Sizewell C Acoustic Fish Deterrent (AFD) Response to EDF Acoustic Fish Deterrent Report (EN010012-006229)

FGS Reference – 1688R0403

Dated: 6th August, 2021

Figure 3.1: Intake Locations (blue lines; 2 from 3 locations on each tunnel to be selected)

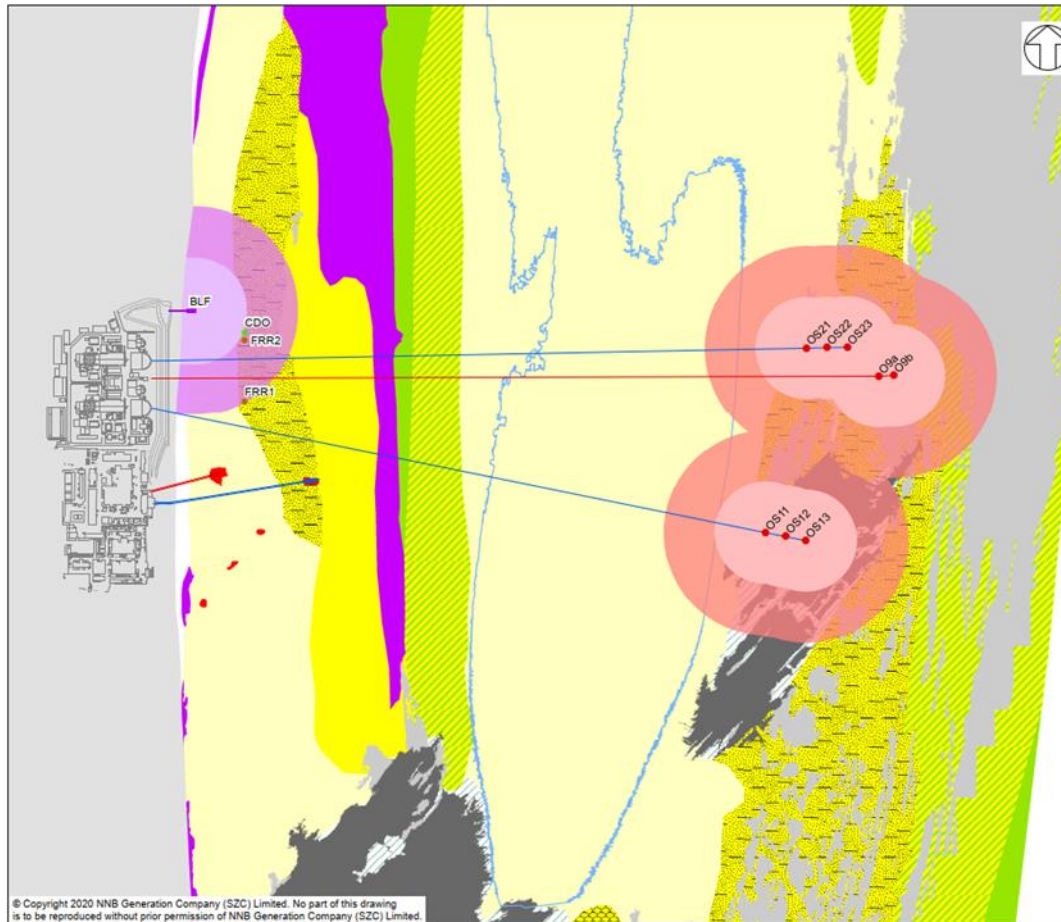
- The report raises the issue of the intakes being located 3km from shore and the issues of powering and accessing the AFD. FGS has previously pointed out that EDF has windfarms located far further out to sea, and spread over a much wider area, so these issues are simply spurious.

Figure 6-1: Typical components of an AFD system (FGS Ltd. 2021; Ref 6)

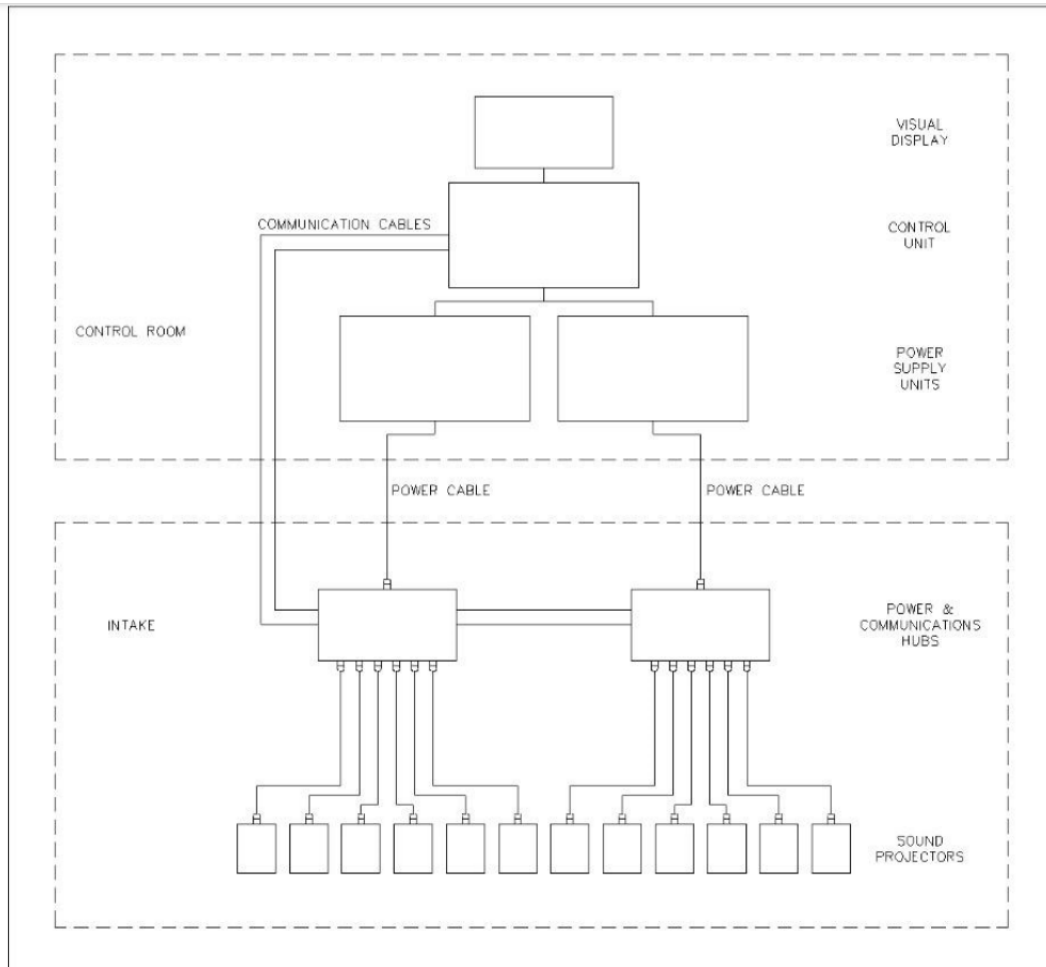
- **The use of ROVs discount the vast majority of the safety concerns EDF raise, as divers can be eliminated from the routine work associated with the AFD.**

- FGS has reached out to an ROV manufacturer, who has reviewed EDF's latest report, and the conditions quoted for the site, and FGS has been advised –
 - **“None of the specifications are show stoppers, its all very doable”**

- The intake and deployment systems will need to be designed for maintenance by an ROV, but that simply requires ROV expertise input during the design phase.

- The ROV manufacturer did also ask, with the intake being so close to the surface, “how does EDF intend to keep the Intake Heads free from biofouling if it doesn't intend to use divers, or an ROV to carry out cleaning?”
